# CITY OF ALBUQUE

Planning Department  
Alan Varela, Interim Director

**Re: Brunacini at 3701 Rutledge Rd. NE**  
**ESC Plan Engineers Stamp Date: 2/22/2022 – D17E003AA7**

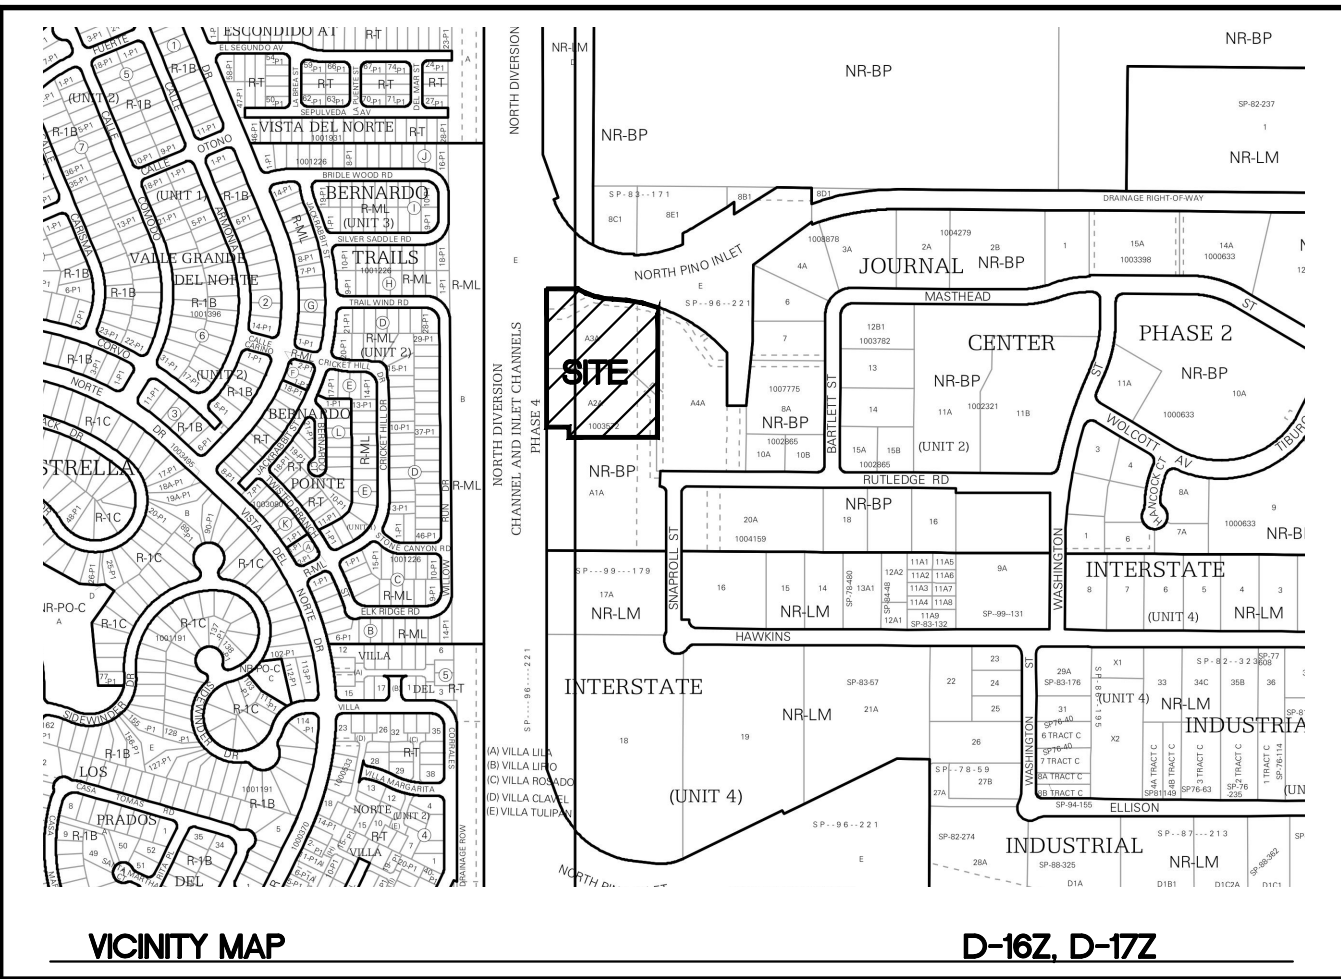
1. The ESC Plan can't be approved until after Hydrology approves the G&D Plan(s).
2. Identify locations of concentrated flow paths that enter and exit the disturbed areas. Identify locations where sheet flow enters and exits the disturbed area. Show on-site drainage patterns of stormwater before and after major grading activities. (CGP 7.2.4.f)

3. The Temporary Sediment Basin (SB) on the west side of this site doesn't appear to be adequately sized. Provide calculations to show it and any other SBs areas sized for the entire area draining to them, both onsite and offsite. (CGP 2.2.12)

4. Sequence Note #4 should be more specifically worded to require the establishment of the SBs as the first item of earthwork construction and prior to clearing the rest of the site.

5. Sequence note #4 should be expanded to address the initial diversion of upstream offsite drainage around the site, and diversion of onsite drainage into the SB in the NW corner.

6. Note #9 in the schedule on sheet SW-1 says "Start construction of residential building pads". This note doesn't seem to apply and should probably be replaced with a note that says construct the commercial building.

8. I can't tell the difference between building, sidewalk, asphalt, and dirt on the ESC Plan. These structures must be clearly identified in the SWPPP per CGP 7.2.4.b.v. The same information is required in the ESC Application. You may attach a copy of the Site Plan to both the SWPPP and the ESC Application to address this requirement.
